ADDISON STORAGE ASSOCIATES, LTD.
LOT 1, BLOCK A
ADDISON STORAGE ADDITION
VOL. 89018, PG. 00078

T.F. STONE COMPANIES, INC.
T.F. STONE BUILDING
LOT 1, BLOCK A, ADDISON STORAGE ADDITION
PAVING AND DIMENSIONAL CONTROL PLAN
ADDISON, DALLAS COUNTY, TEXAS

DATE: 1/14/03
O.E. JOB NO. 138-02
SHEET NO. 3
OF 9 SHEETS

T.F. STONE COMPANIES, INC.  
T.F. STONE BUILDING  
LOT 1, BLOCK A, ADDISON STORAGE ADDITION  
**PAVING AND DIMENSIONAL CONTROL PLAN**  
ADDISON, DALLAS COUNTY, TEXAS

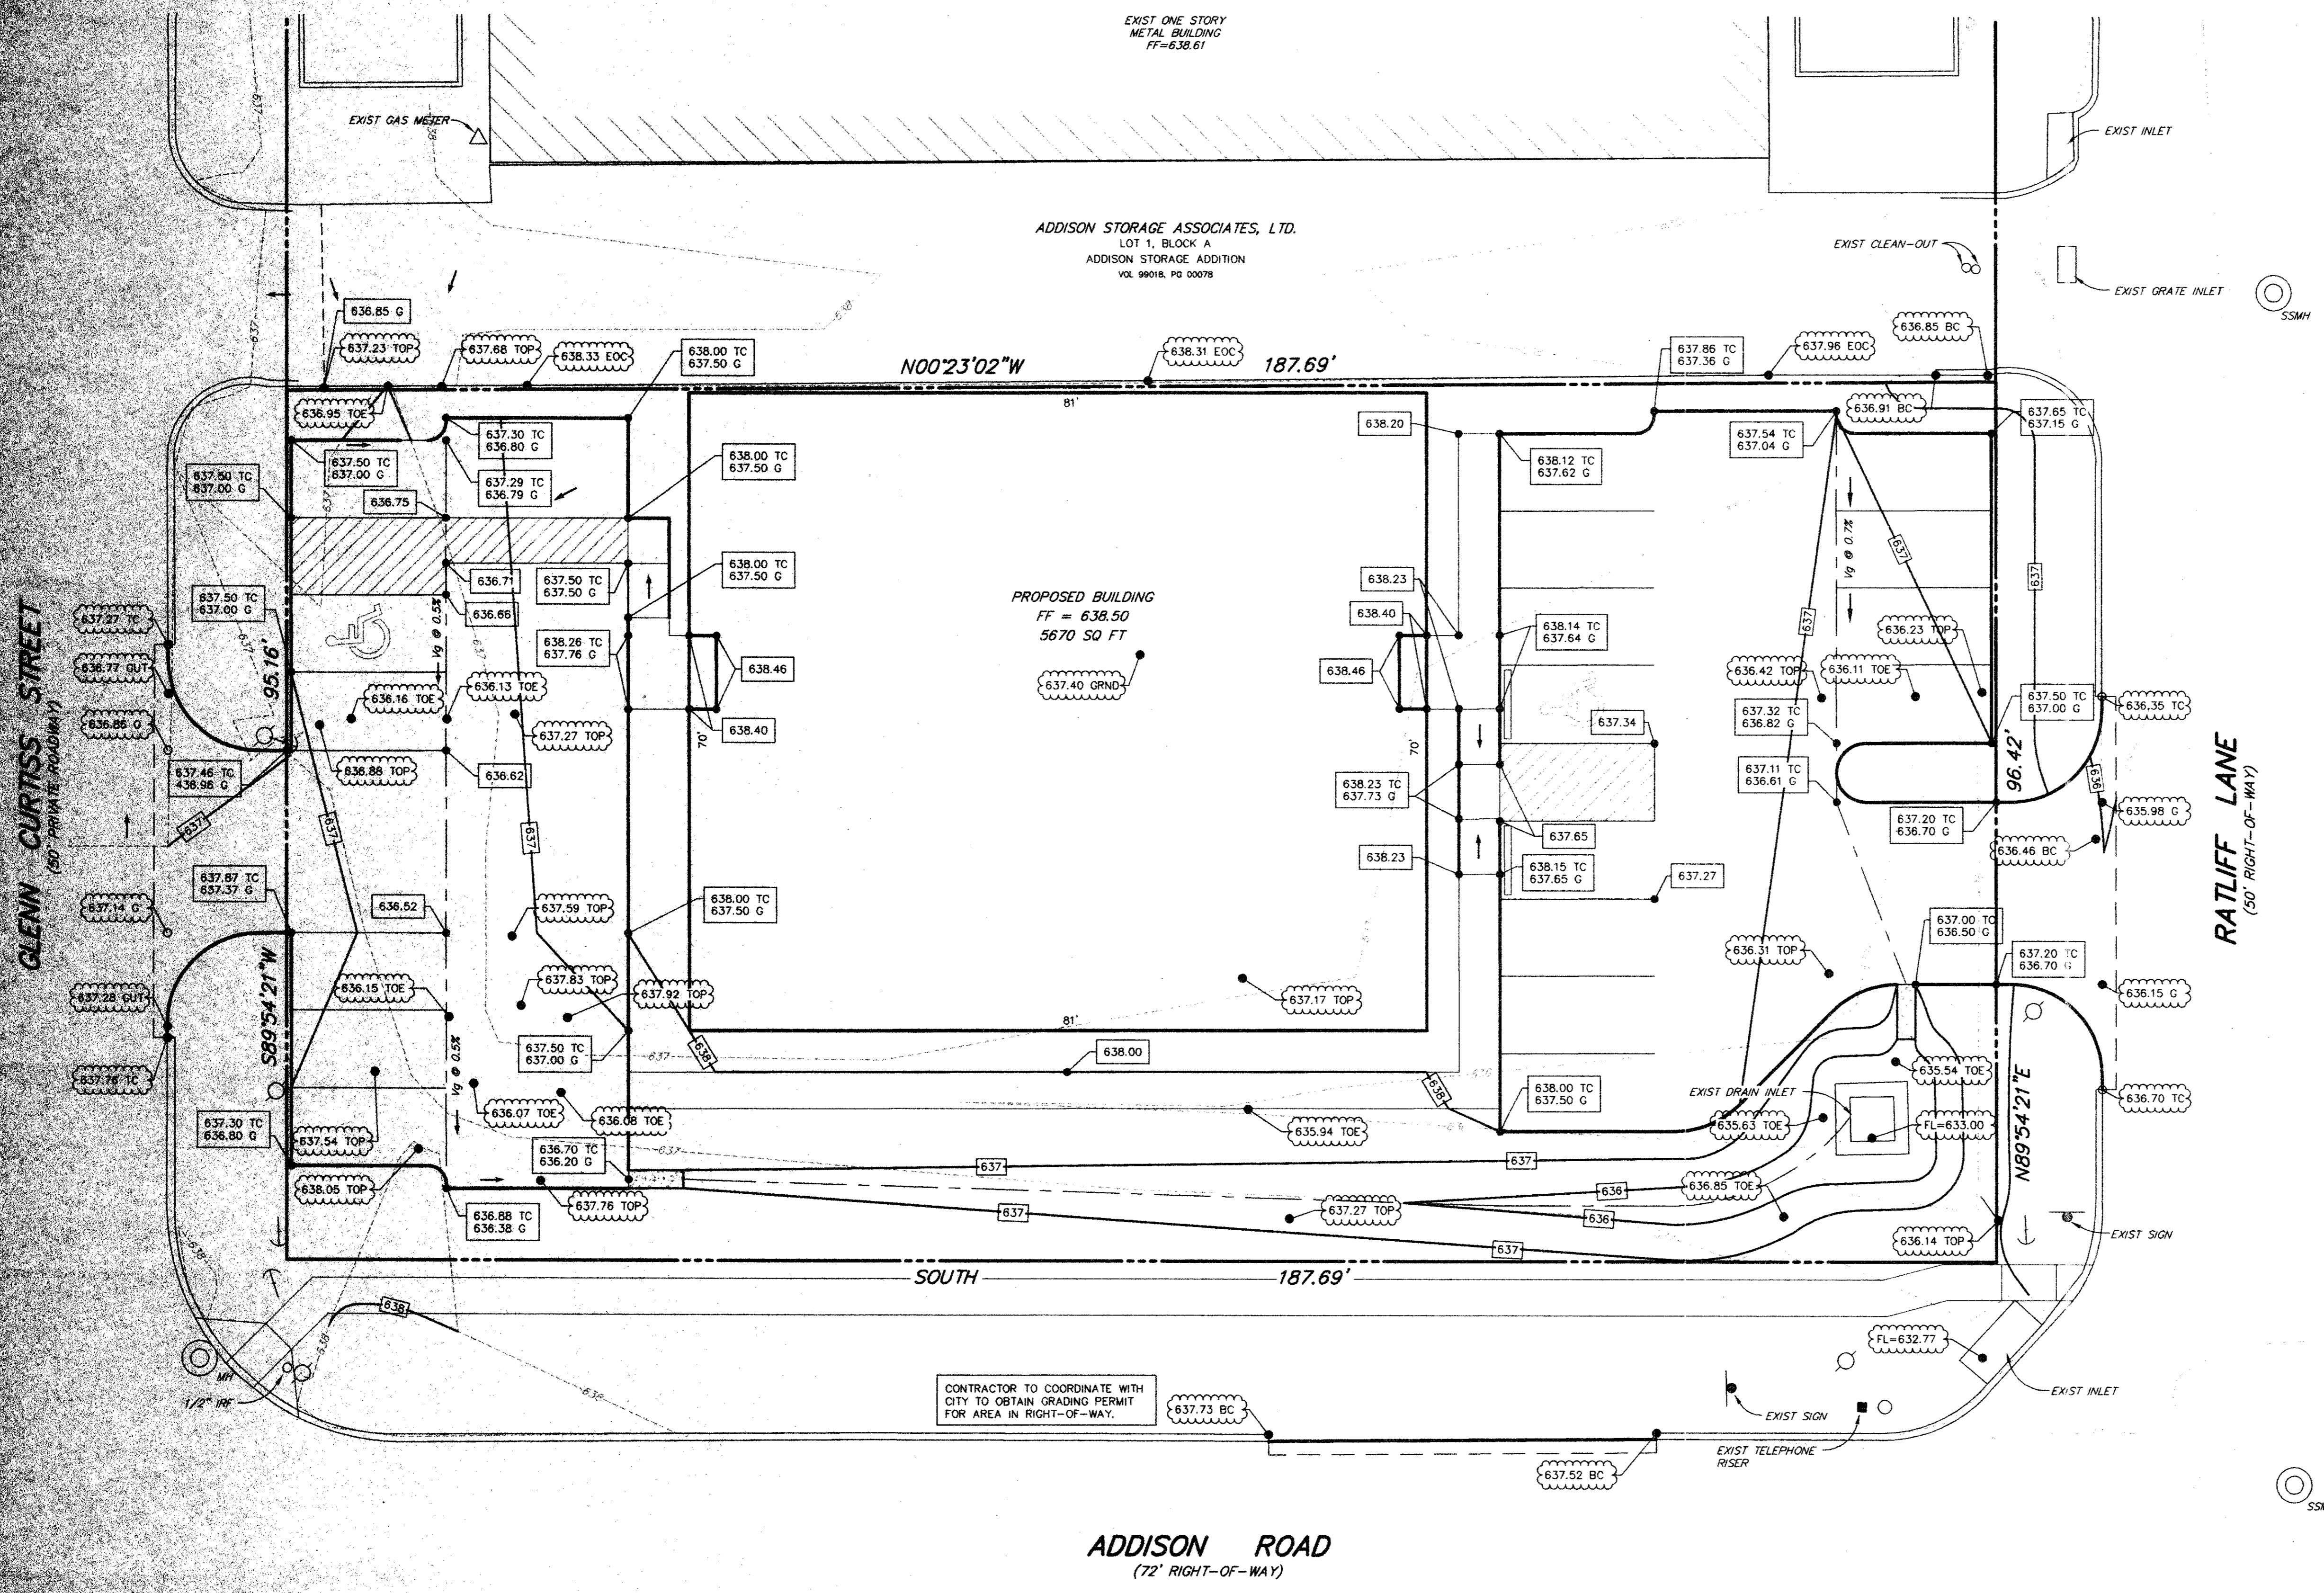
We need to look at how we want the ramps to look here. There will be some curb removal.

NOTE: EITHER EXTEND THE SIDEWALK AROUND AS SHOWN, OR PLACE AN ADA RAMP!
